# CITY OF ALBUQUERQUE

**Re: Glendale Development Lot 30 Grading and Drainage Plan**  
**Engineer's Stamp dated 6-20-09 (B20/D20)**

GRADING & DRAINAGE PLAN

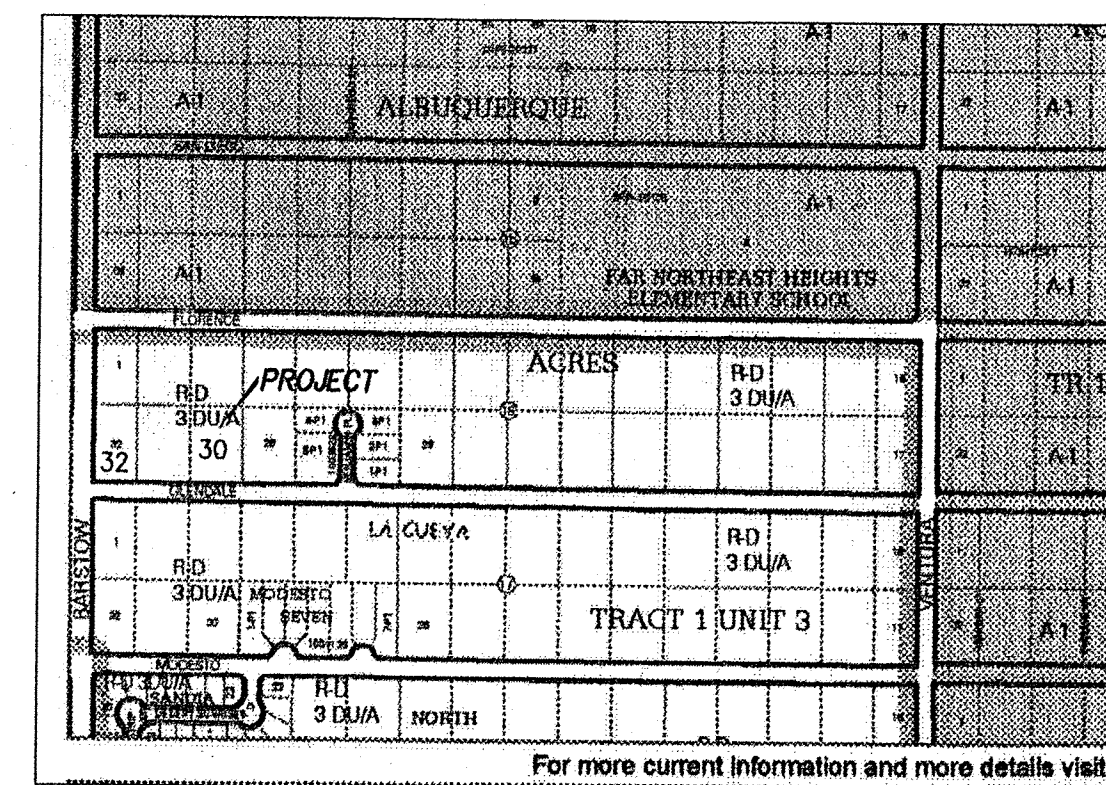
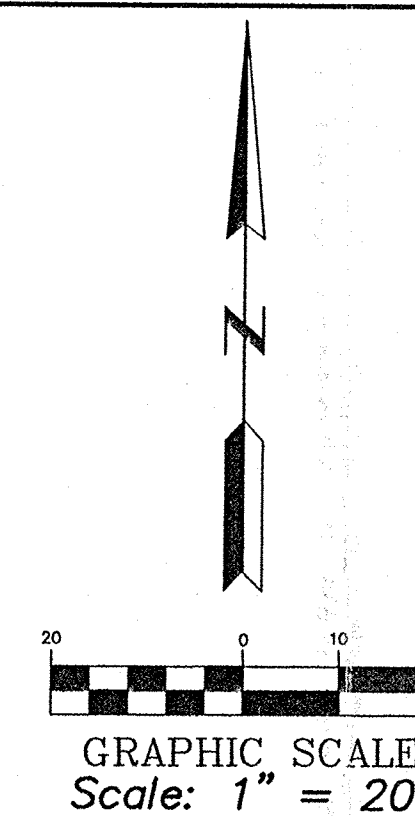
- Per the NAADMP, all developed runoff from this lot must drain to Glendale. Any change must address downstream capacity and all drainage easements must be provided.
- It appears that retaining wall must be built on both the east and west sides of this lot. Please provide all critical top-of-wall and bottom-of-wall elevations. It is especially important next to the existing block wall on the east side (which I will assume is not structural at all).
